## 415 Cumberland Avenue - Review of Final Design Proposal

Thank you for the opportunity to review ALPHA Architect's final design proposal (dated July 20) for the renovation of 415 Cumberland. The following comments are pursuant to Sec. 14-526 (b) of the site plan ordinance which requires historic preservation staff or Board to provide comments to the Planning Board regarding the relative compatibility of the project on the abutting historic resource or district. In this particular instance, the subject building itself, while located outside the designated historic district, is an architecturally notable structure, warranting careful rehabilitation and sympathetic additions.

FOREST AVENUE ELEVATION  
SCALE: 1/8" = 1'-0"

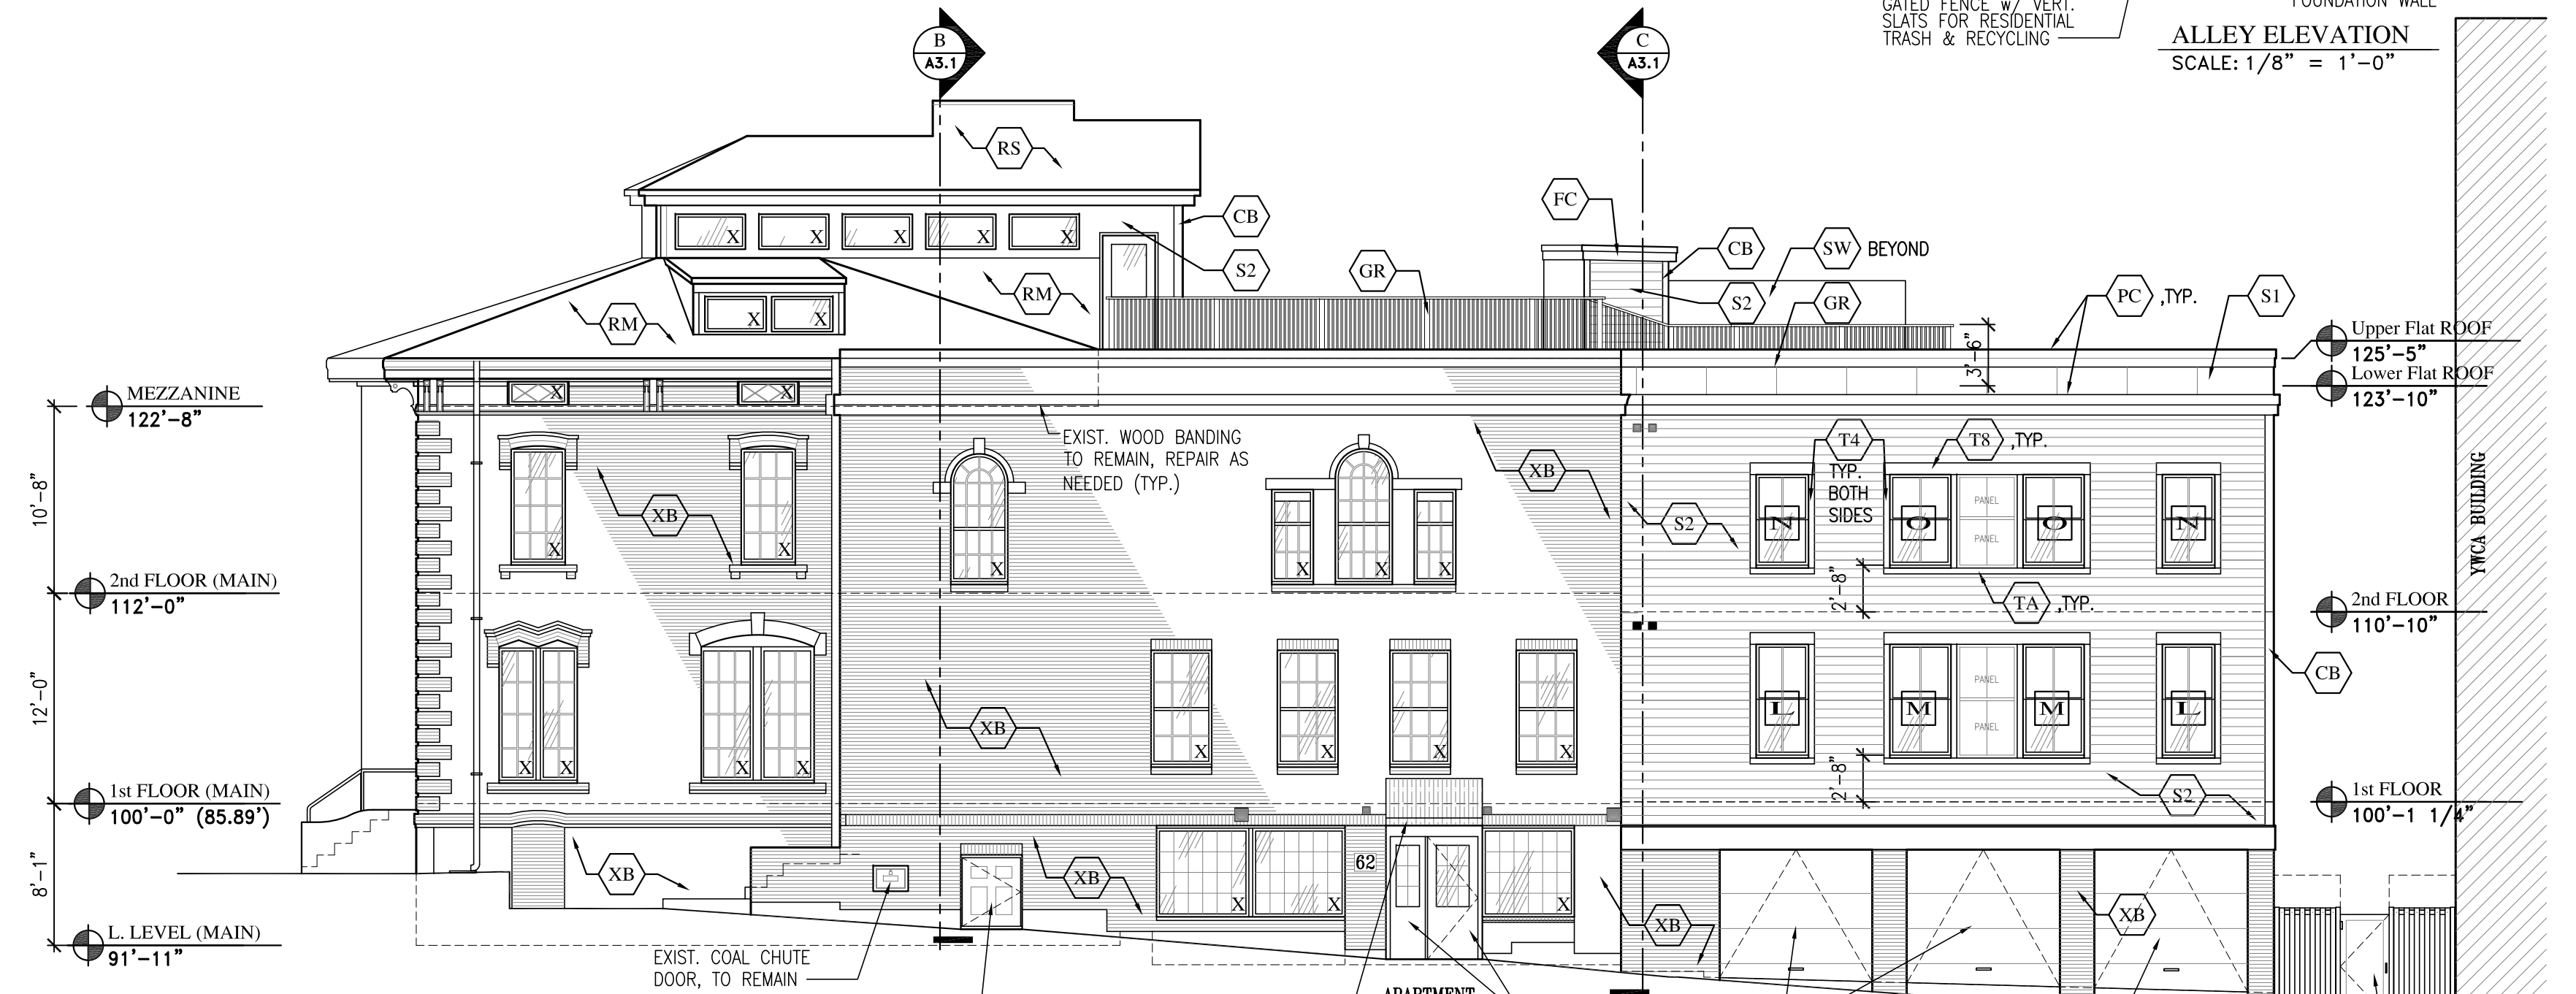
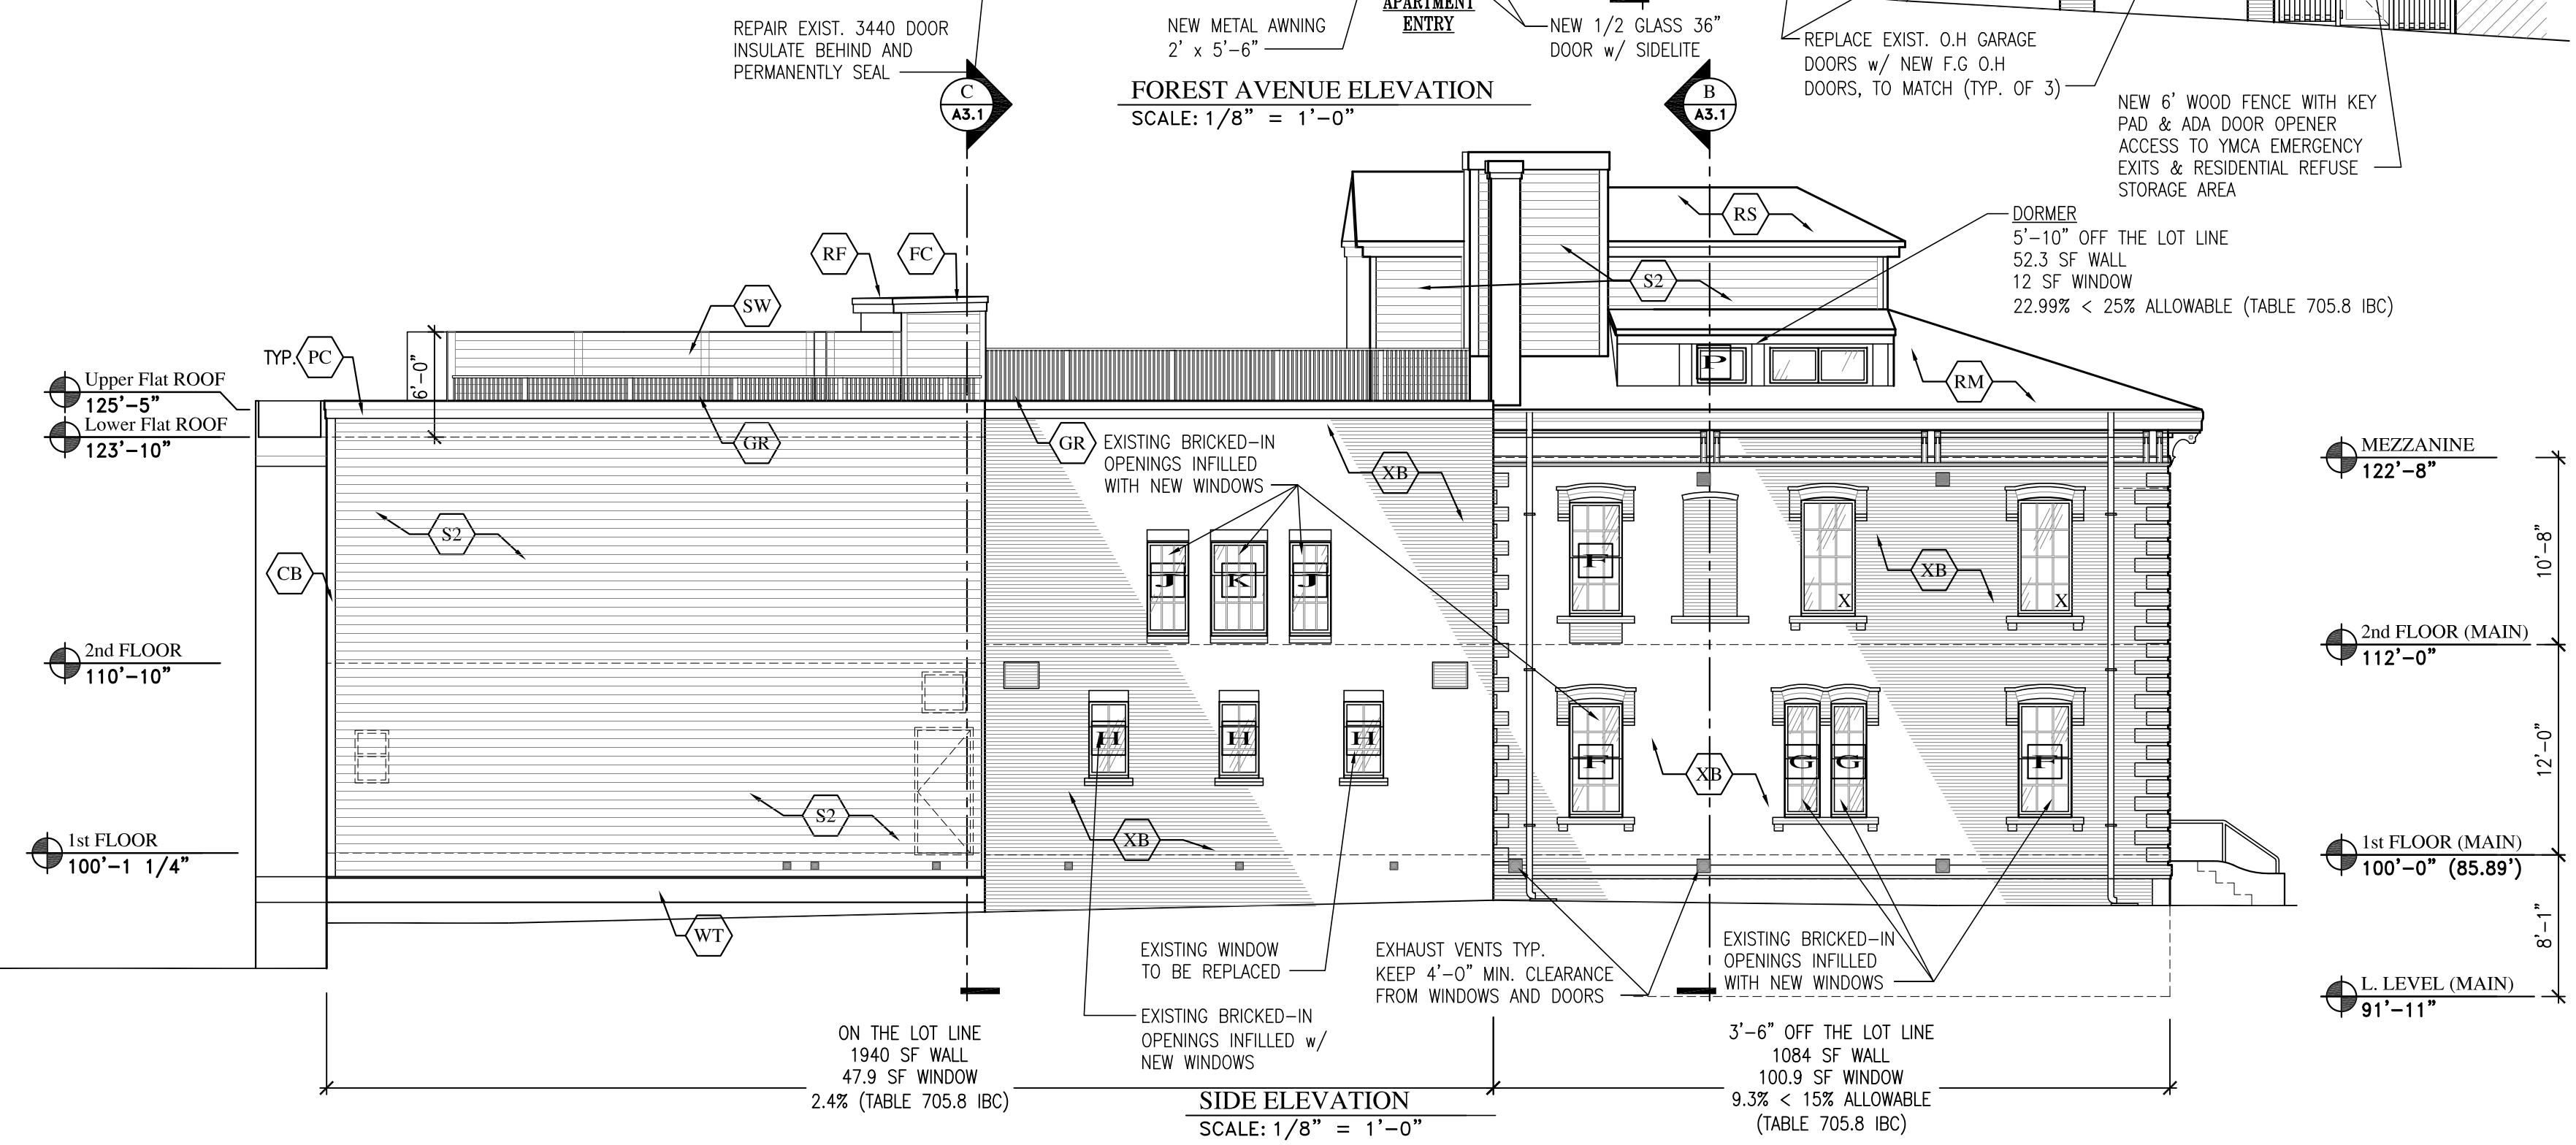
The 7/20 design appears to be responsive to most of the previous review comments provided by this office, as well as comments of the Planning Board and staff. The one outstanding issue that might warrant further consideration is the replacement exterior cladding proposed for the rear addition facing Forest Avenue. Although the material itself is acceptable and its running bond pattern relates to the running bond brick of the abutting historic structure, staff suggests that the scale of the individual cement panels be reduced somewhat. A reduction in scale of individual modules would likely result in a more subtle and intentional relationship between the finer grain brick of the historic structure and the contemporary exterior of the addition. Also, staff suggests that the tone of the addition be darker than what is presented to provide a more recessive appearance.
